Our ref: STH19/00167/03
Contact: Hayley Sarvanandan 4221 2423
Your ref: SSI-9973

3 June 2020

EASTERN GAS PIPELINE MOD 1 (SSI-9973) – PROPOSED PIPELINE FROM PORT KEMBLA TO CRINGILA

client: JEMENA		
project: MODIFICATION REPORT PORT KEMBLA LATERAL LOOPING PROJECT		
title: PROPOSED PROJECT LOCATION		
project no: MELEN269488-R03	figure no: FIGURE 2	rev: A

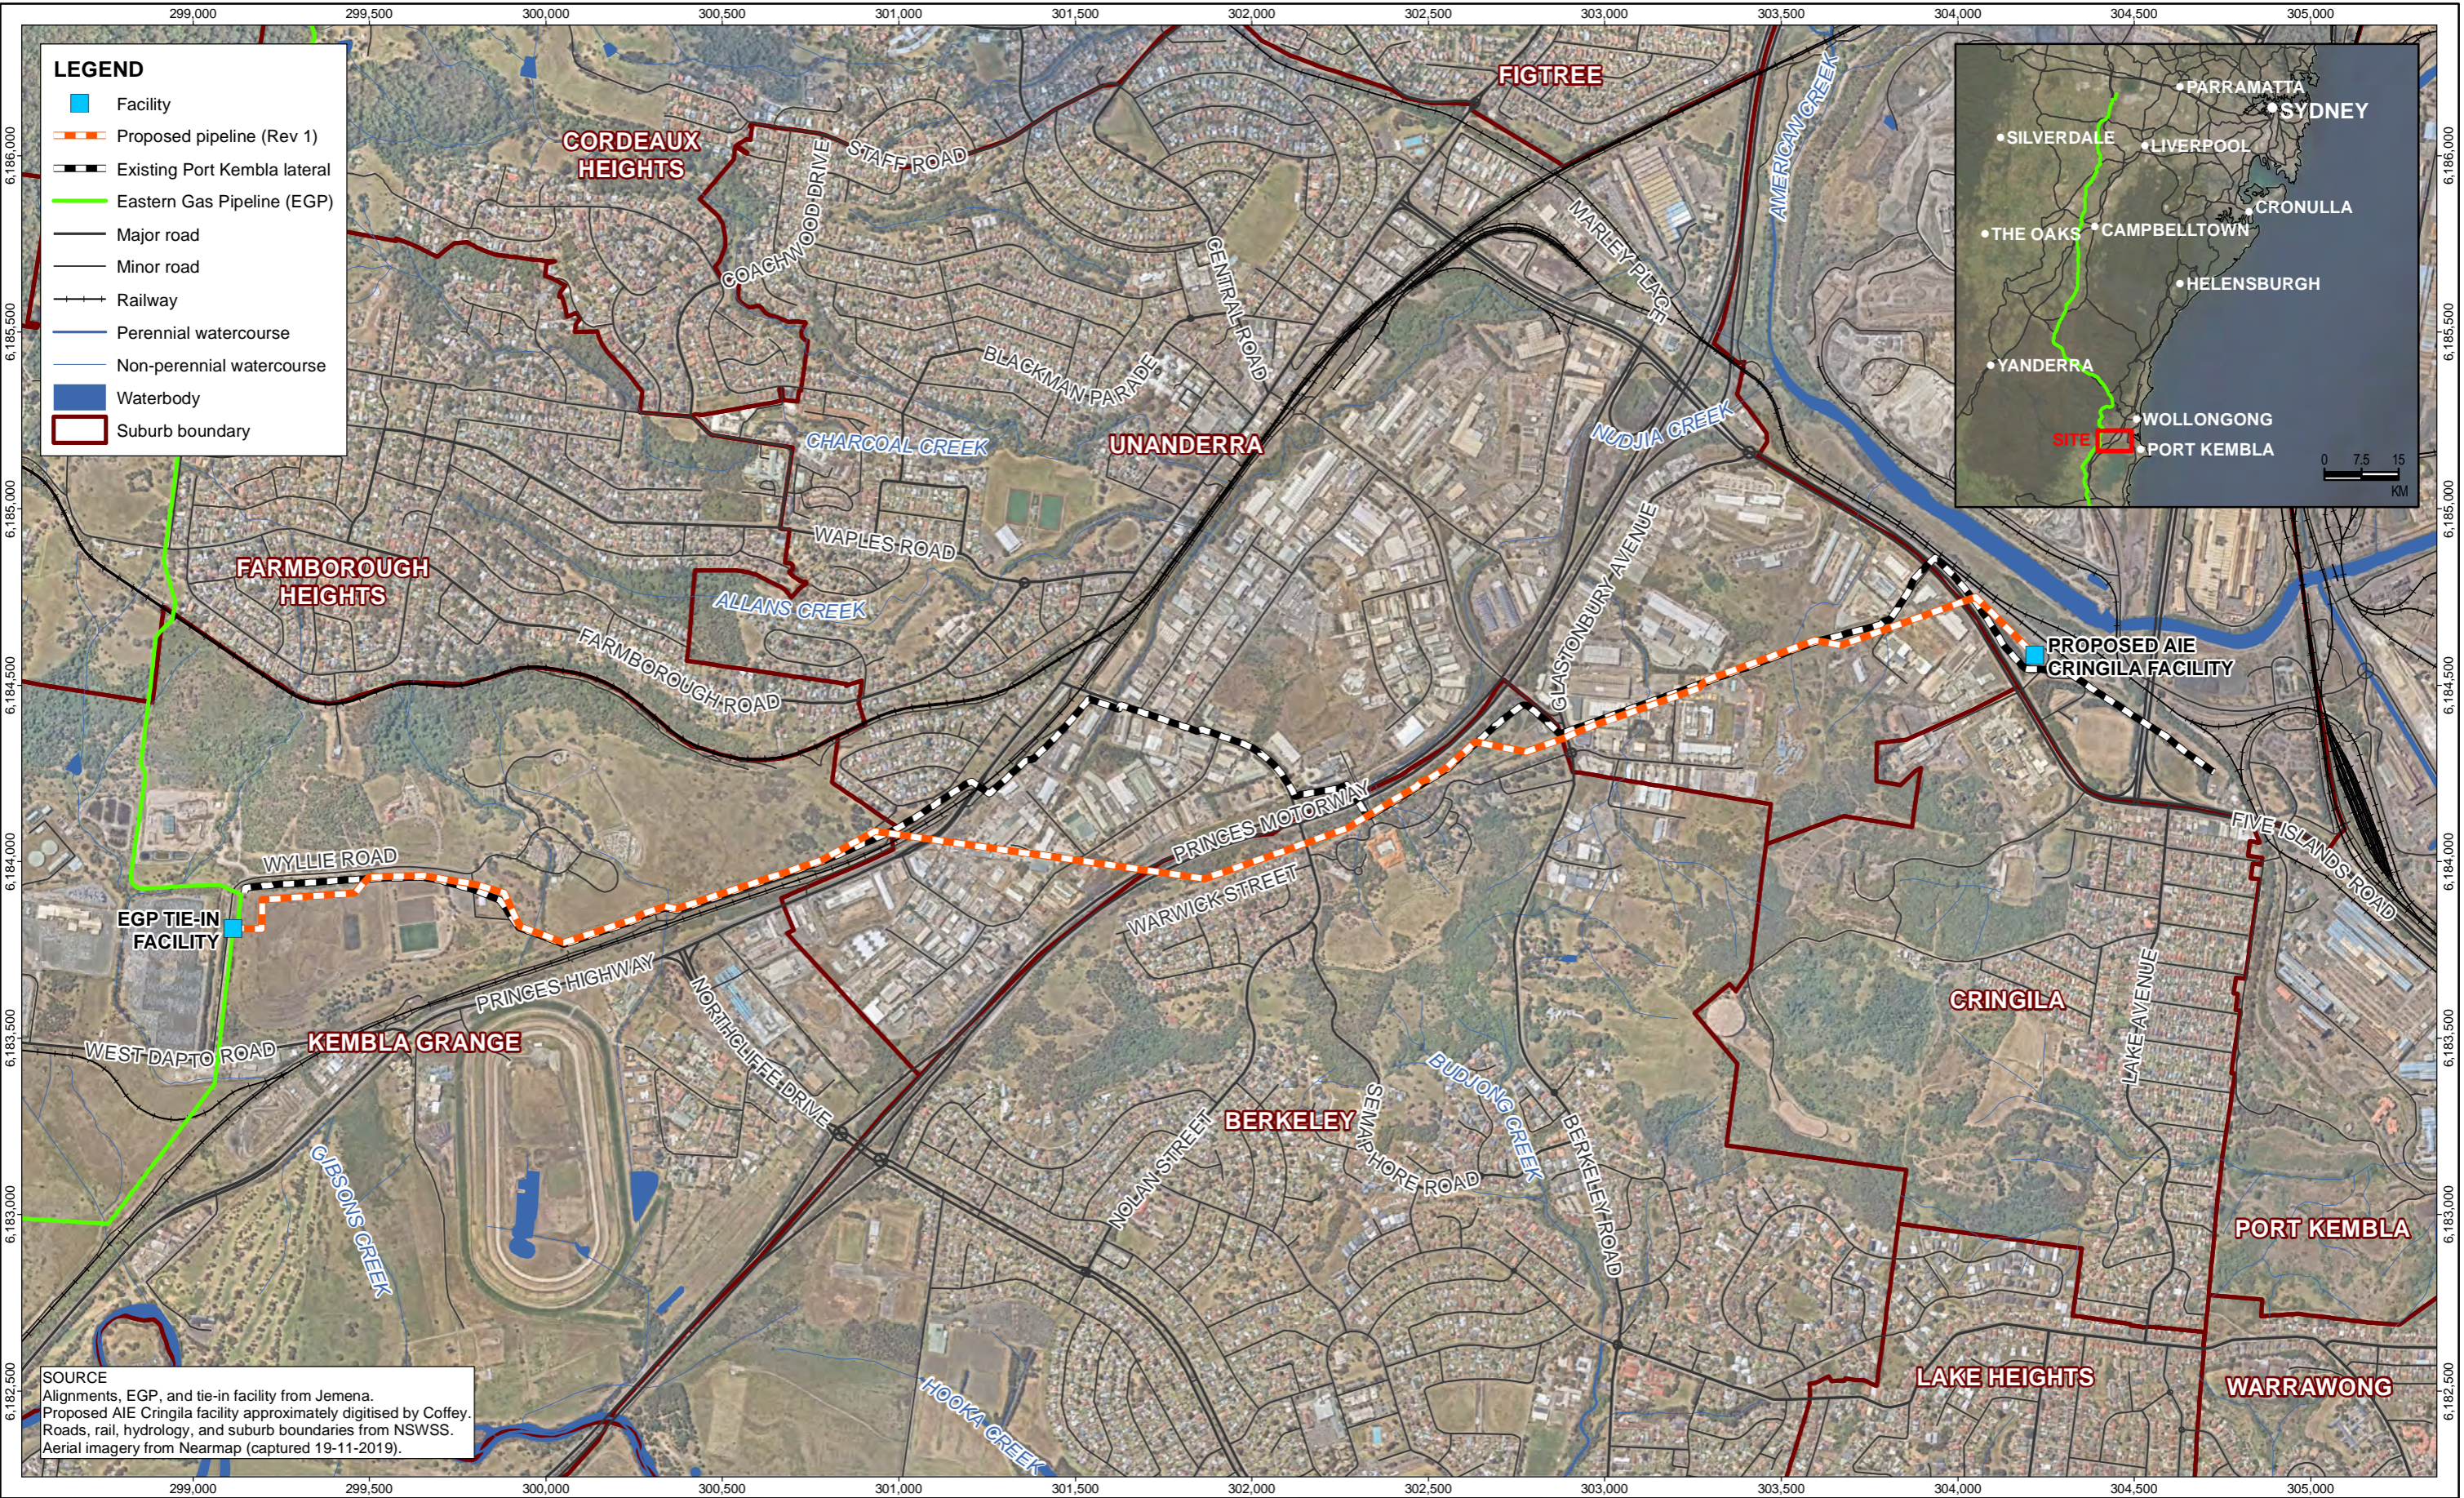
1. **Pipeline Route:** The route for the additional pipeline shown in section 1.3 of the Modification Report appears to cross the Princes Motorway and Five Islands Road at different locations to the existing EPG. Easements will be required at these locations.
